DECISION DELEGATED TO HEAD OF PLANNING

Application No: H14-0922-24 **Applicant:** Mr A Rowe

Proposal: Details of site levels & floor levels, boundary treatments & scheme of landscaping (Conditions 5, 6 & 7 of H14-0633-21)

Location: Land Off Spalding Road Pinchbeck Spalding

CROSS SECTION A-A 1:200

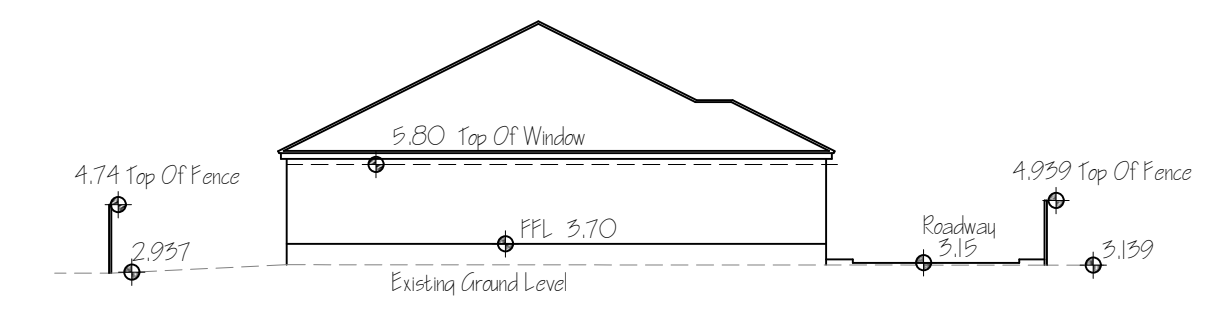
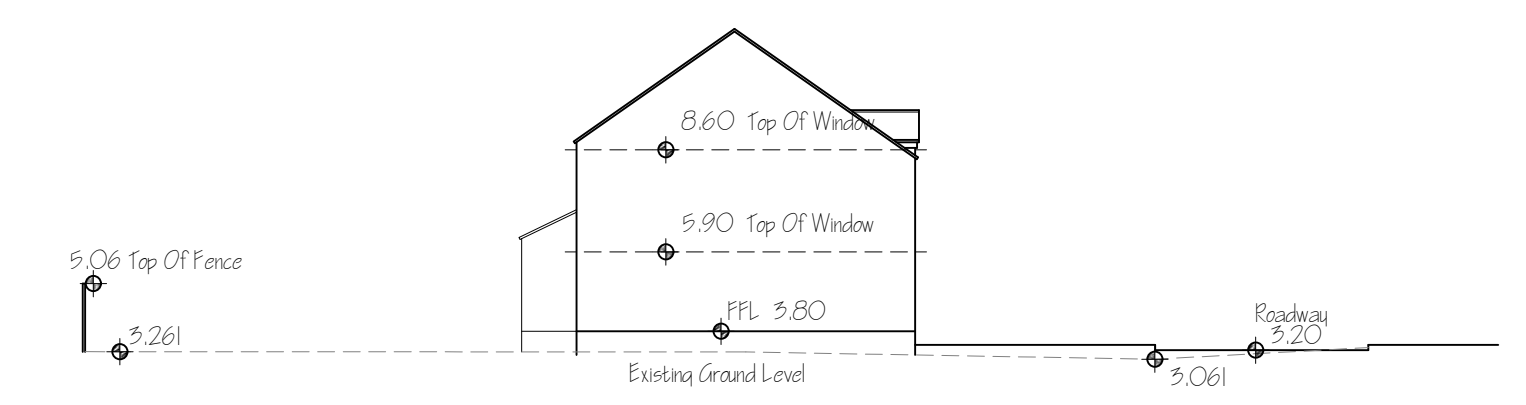
The detailed submitted show that finished floor levels have been raised at least 500mm above existing levels, in accordance with Condition 12 of the same permission. Finished floor levels would be raised no more than 670mm above existing ground level, which averages to no less than 500mm above road level.

The submitted cross sections show an acceptable relationship with neighbouring dwellings. As such, the submitted details are considered acceptable and Condition 5 can be discharged.
